MEMORANDUM

TO: Jean Fraser, Planner
FROM: David Senus, P.E.
DATE: December 6, 2013
RE: Munjoy Heights, Final Level III Site Plan Application

Woodard & Curran has reviewed the Final Level III Site Plan Application for the proposed infill residential development located at 79 Walnut Street in Portland, Maine. The project consists of the development of 29 townhouse style residences.

RAIN GARDEN OR BIORETENTION CELL DETAIL
NOT TO SCALE

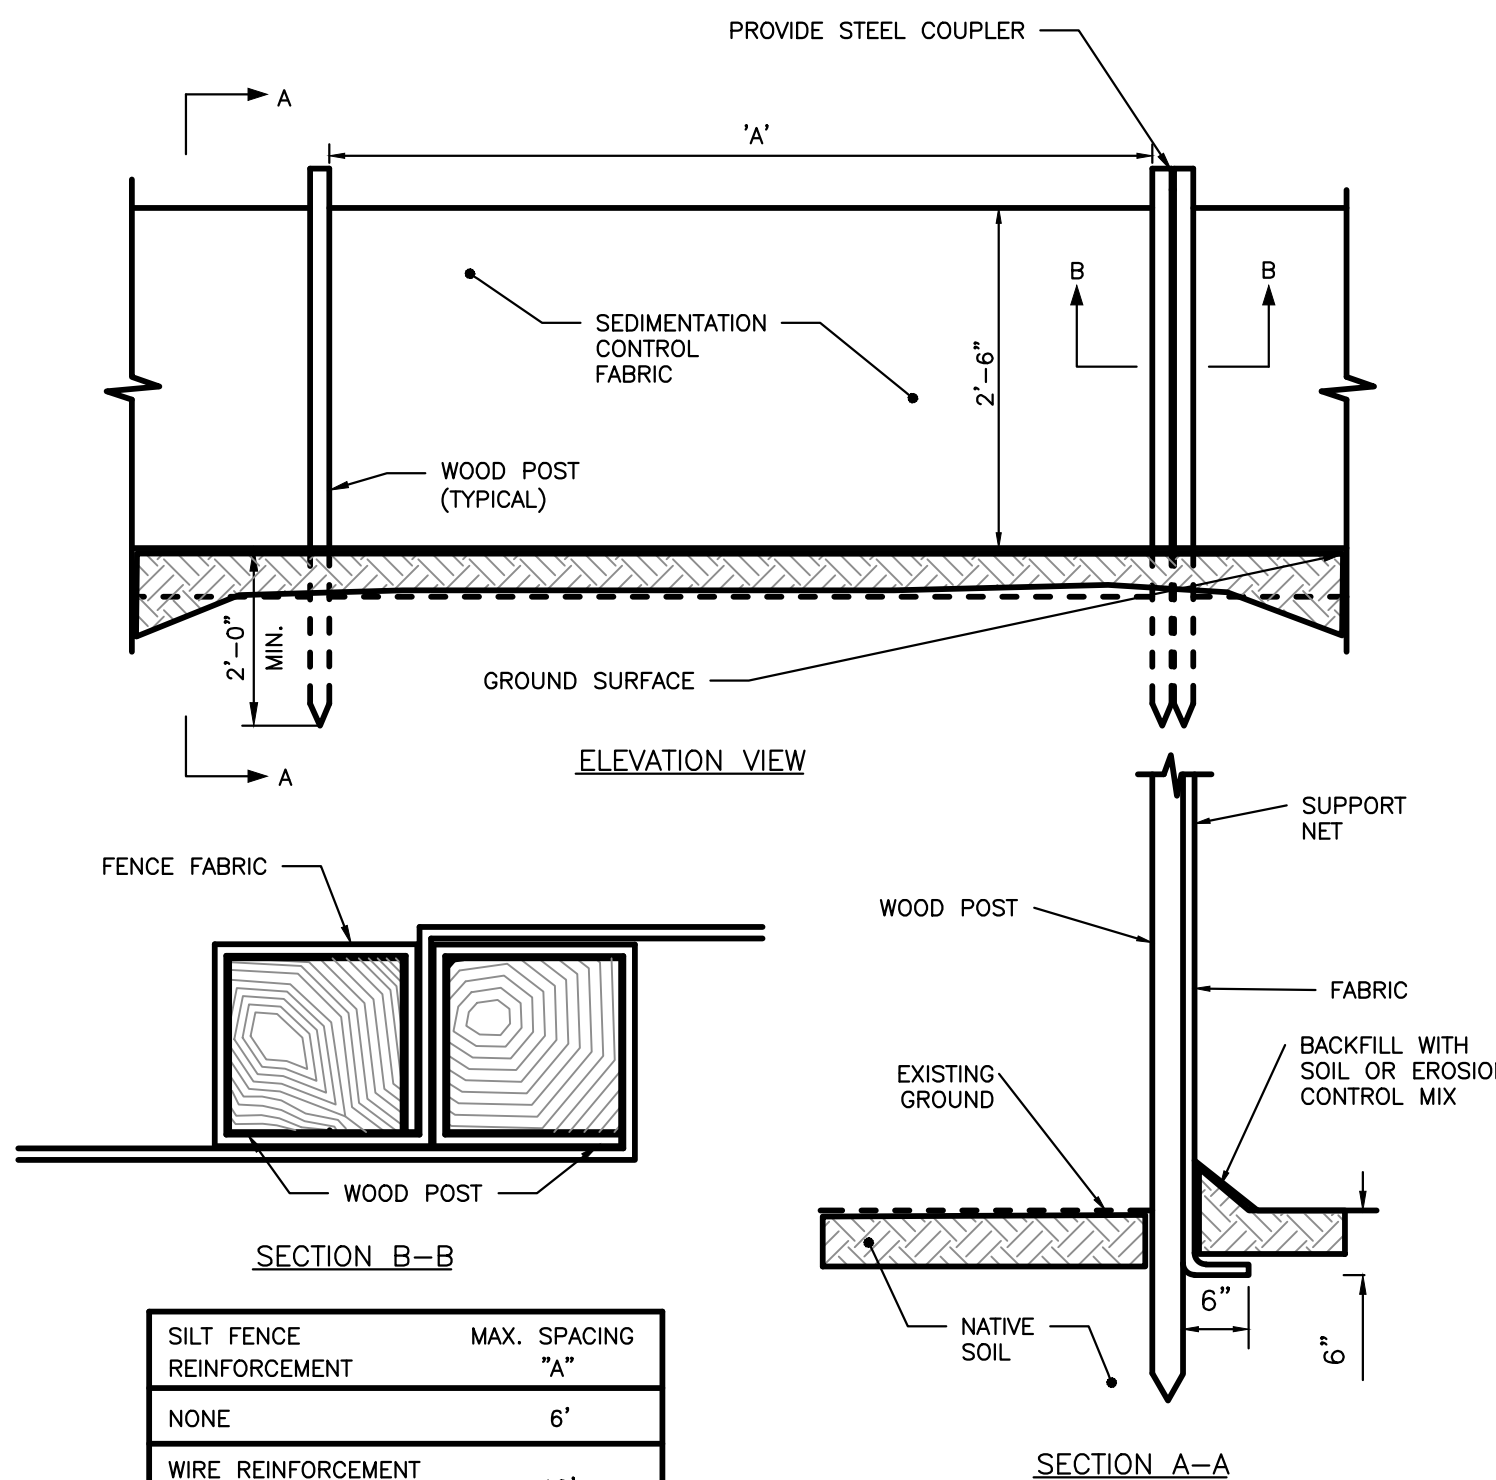
- 3) Comment adequately addressed relative to the Underdrained Subsurface Sand Filter. The plans contain additional details on two underdrained soil filters / rain gardens. It appears these systems were designed without an impermeable liner. We request review and comment on these systems by the project's geotechnical engineer.

- 16) Comment adequately addressed.
- 17) The details provided for the underdrained soil filters (rain gardens) on C-42 do not provide sufficient detail at the edges of the system, where the in-slope meets the driveway/walkway pavers. The in-slope should be designed with measures to avoid erosion and under-mining of the adjacent pavers. As noted in Comment #3, the soil filters are not currently designed with an impermeable liner below the underdrain. The project geotechnical engineer should review the design to ensure that the introduction of surface water to the subsurface soils will not create geotechnical concerns.

DRAWING NO. C-30

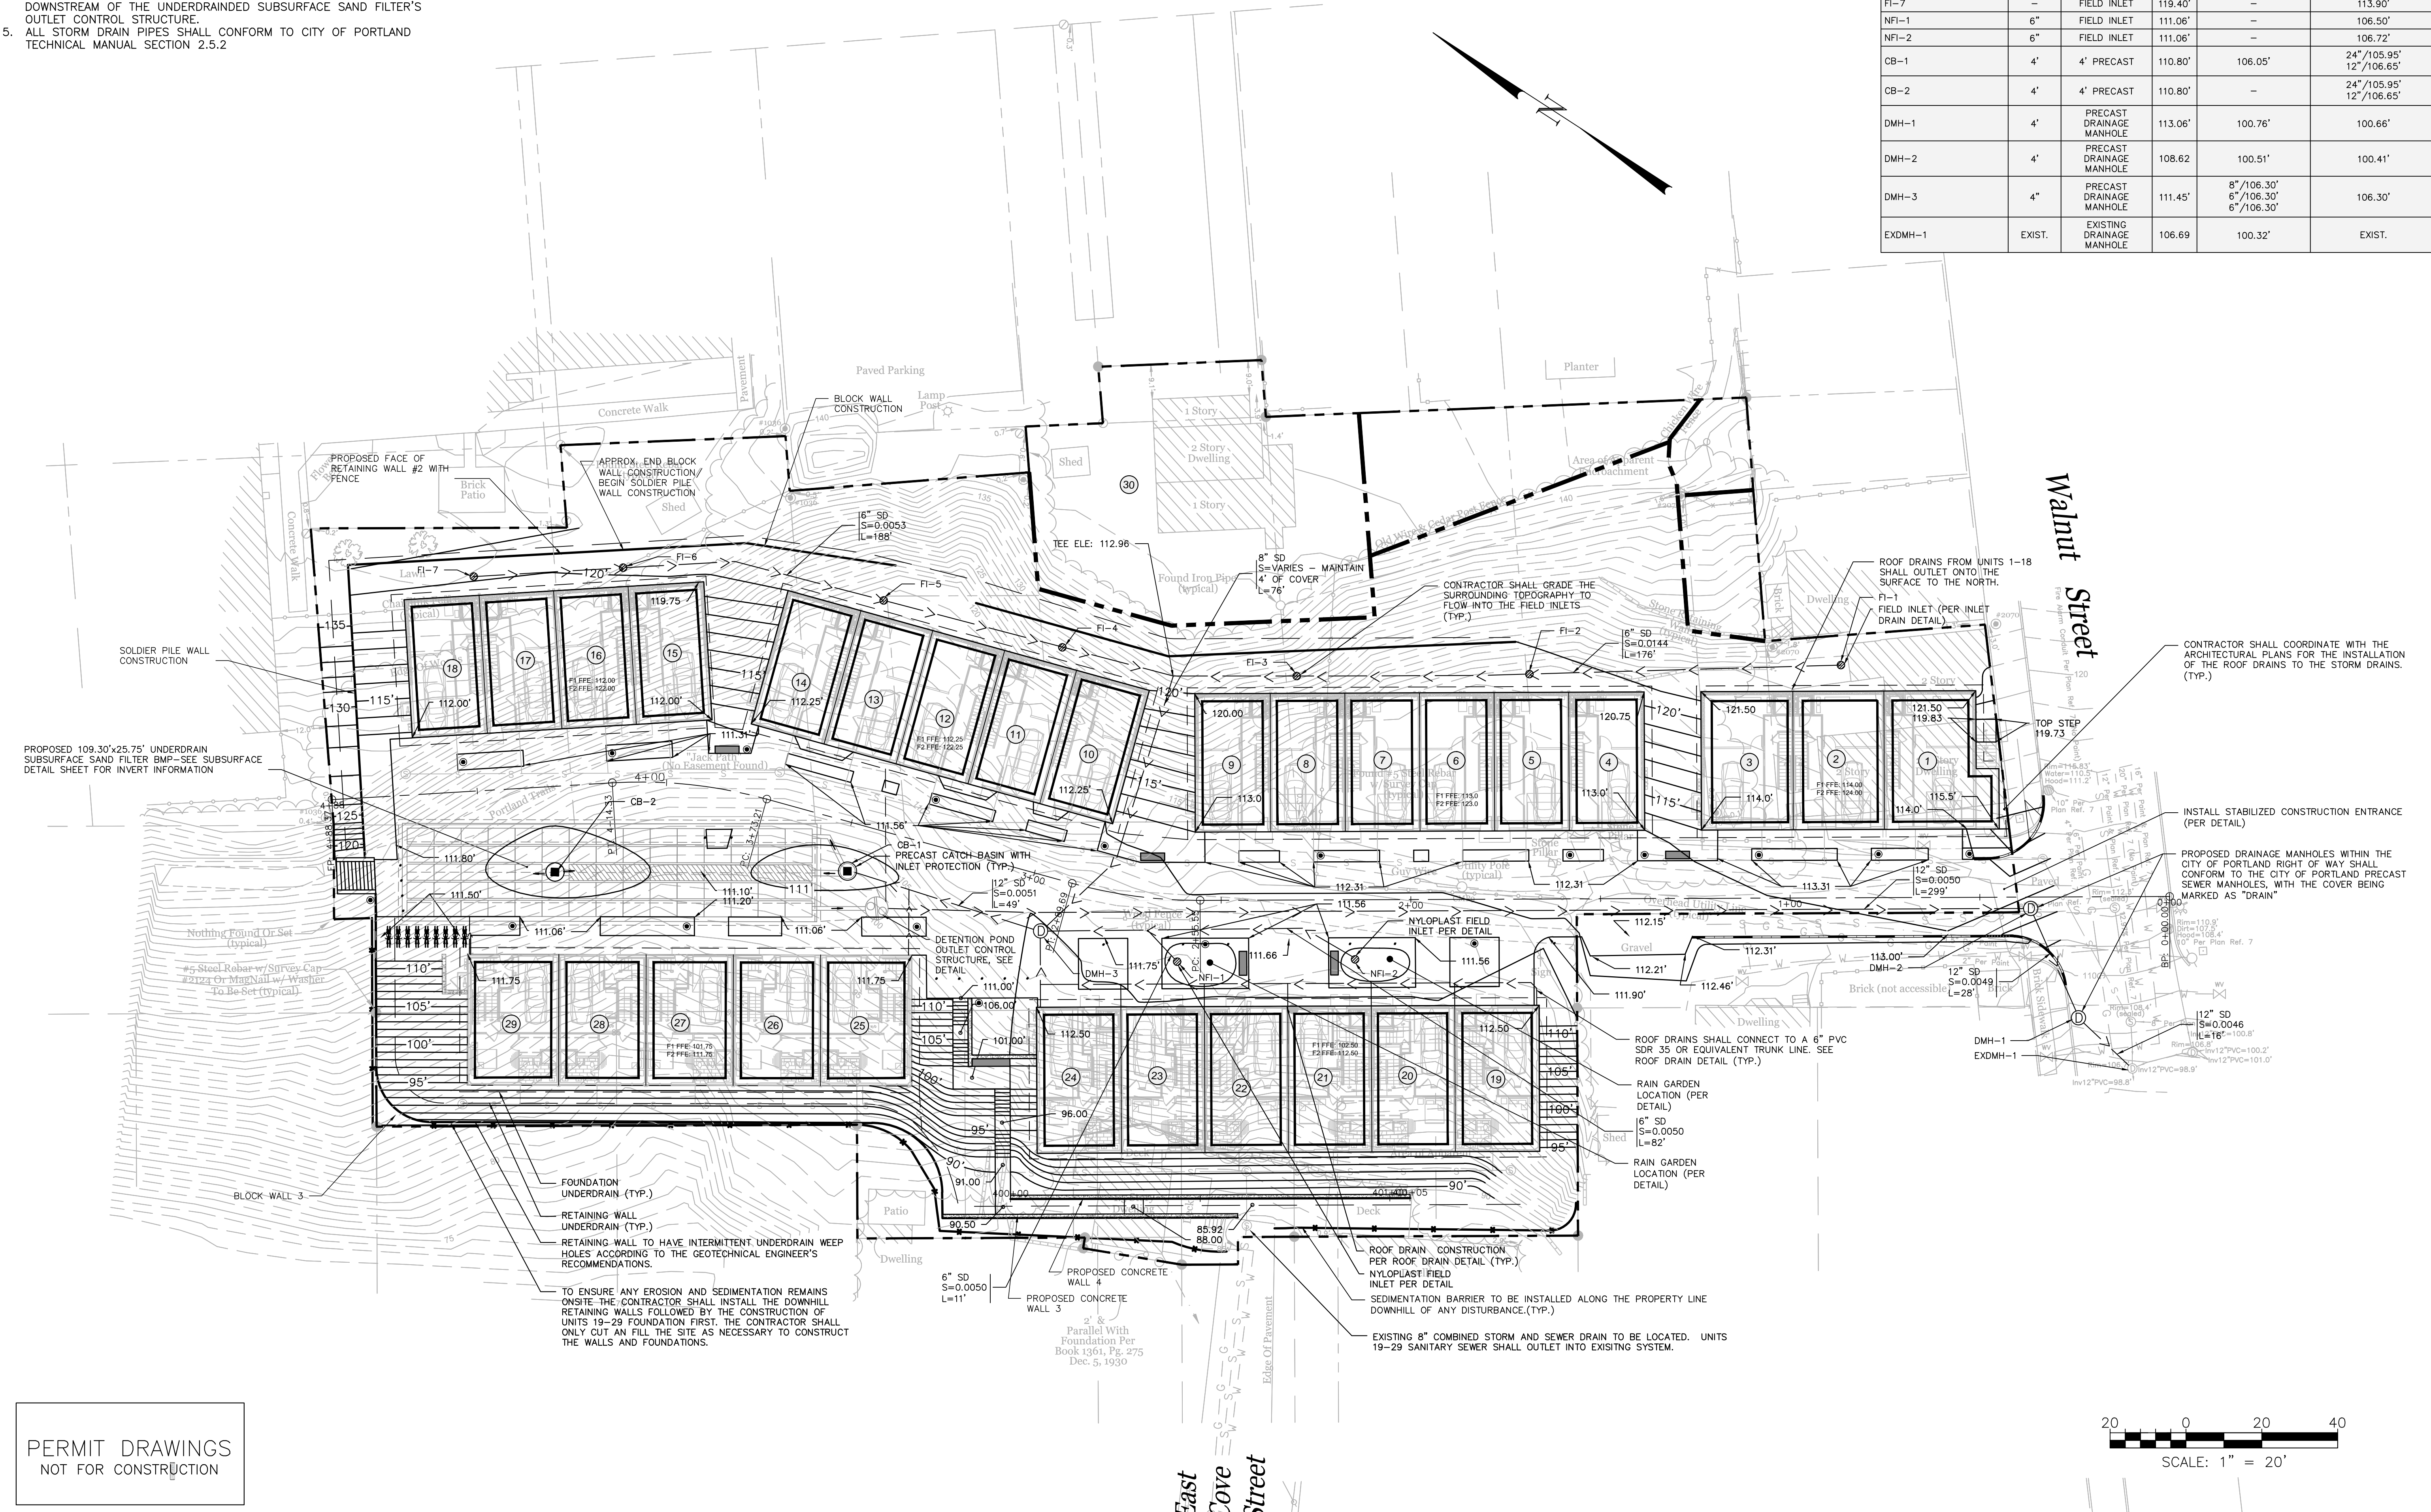
- 1) a), b) & c) (i.)(ii.)(iii.) – Comments adequately addressed.
- 2) a), b) & c) – Comments adequately addressed.
 - d) Sheet C-30: The access/diversion structure labeled CB-1 has two outlets, a 12" pipe and a 24" pipe. The 24" pipe connects to the Isolator Row, whereas the 12" pipe appears to connect to an adjacent standard chamber. Please clarify the intent of 12" pipe, along with the invert elevation. Because the Isolator Row is intended to remove sediment and debris from the stormwater flow, we would not anticipate that the 12" pipe invert elevation would be set the same as the 24" pipe invert elevation. If the 12" pipe is acting as a high-flow outlet, we would anticipate that the invert elevation of this pipe would be set higher than the 24" pipe.
